**From:** Contact Centre (CRM) <contact@ribblevalley.gov.uk>  
**Sent:** 08 June 2023 09:29  
**To:** Planning  
**Subject:** Planning Application Comments - 3/2023/0234 FS-Case-522352405

**Planning Application Reference No.: 3/2023/0234**

**Address of Development:** 95 Mellor Lane, Mellor, BB2 7EN

PROPOSED SITE PLAN

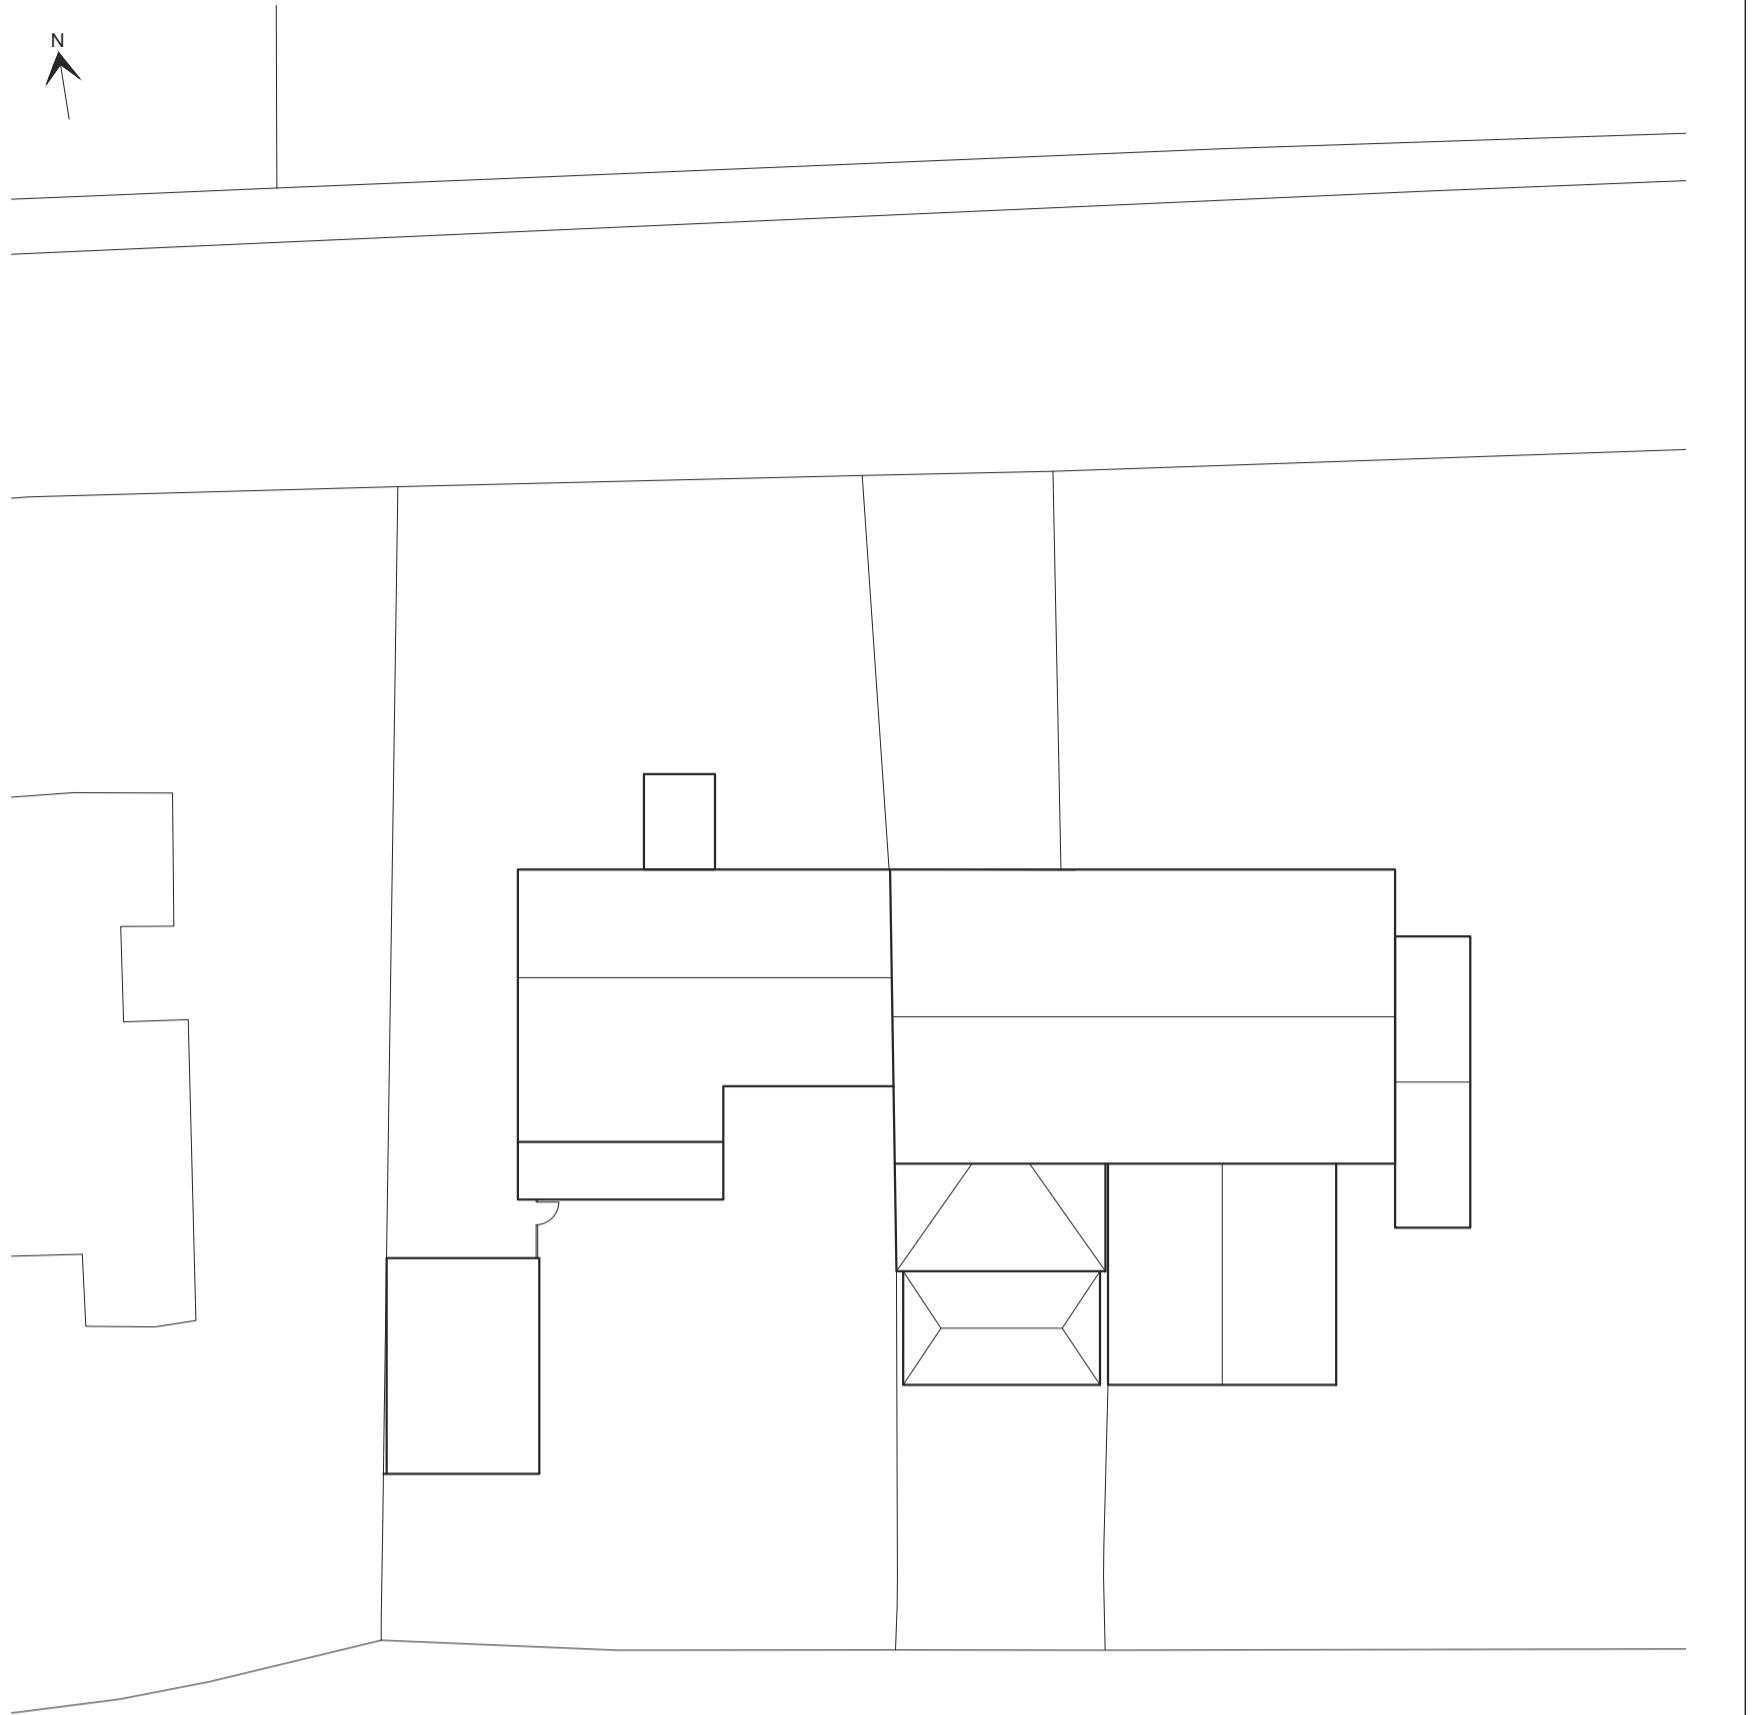
**Comments:** [REDACTED] site on which the planning application has been presented. I am mostly in favour of the developments as the house needed a lot of TLC. The proposed plans will make it a much nicer property. My only concern is with the proposed wind turbine to the rear of the property. The houses on that stretch of Mellor Lane have wonderful views out of the back over to the West Coast and the Ribble Estuary and I don't want my view to be spoiled. The plans indicate the wind turbine will be 9m in height, which seems pretty tall and might dominate the views. Further to that, I would be concerned as to the amount of noise that is generated from the wind turbine whilst it is in operation. I would appreciate some clarity over both the height of the proposed wind turbine and the noise levels before accepting this particular element of the proposal.
